**Proposed Variation of Planning Condition No 5 accompanying
Planning Approval 20 00859/FUL**

The applicant seeks planning permission to undertake development with a minor variation substituting drawing 058/2019/SK250920 P3 with drawing 058/2019/14/P5

Drawing Number: **058/2019/14** Revision: **P5**

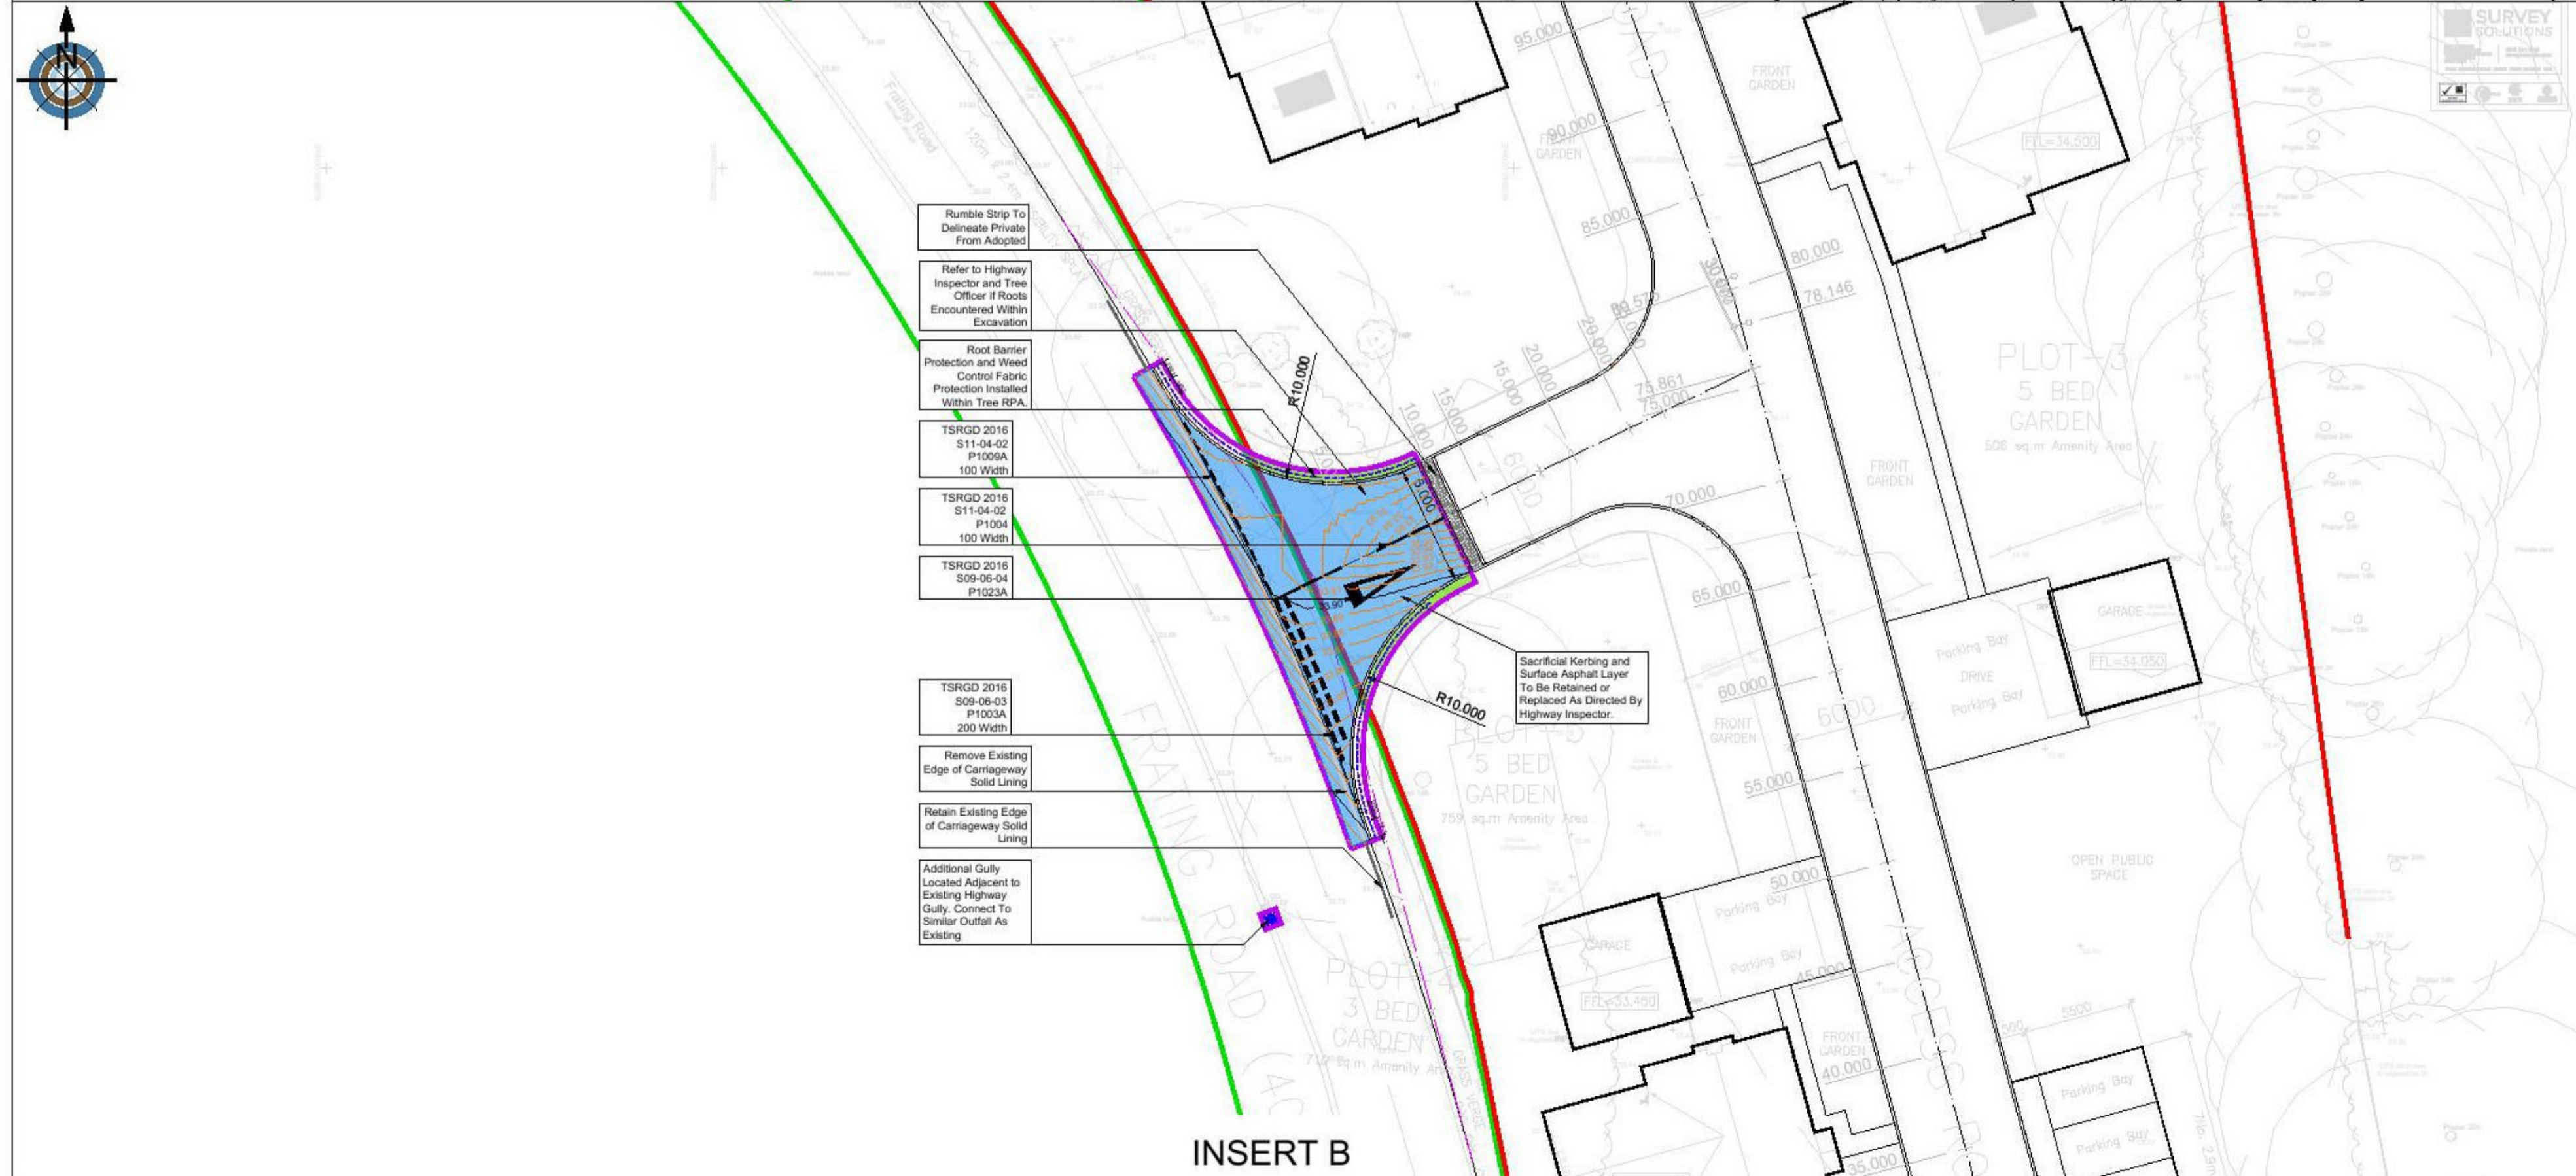
Pursuant to the approval of Planning Application 20/00859/FUL, ECC's passenger transport and strategic team confirm that the most suitable position for the bus stop is the south side of Harwich Road, east of Frating Road Frating Road; this together with footway works on the northside of Harwich Road.

ECC has now confirmed a shelter will not be required at either location.

- the bus stop location requires a variation to the planning
- there is a reduced scope of works
- the bus stop will be in the visibility splay
- an exception report is justified
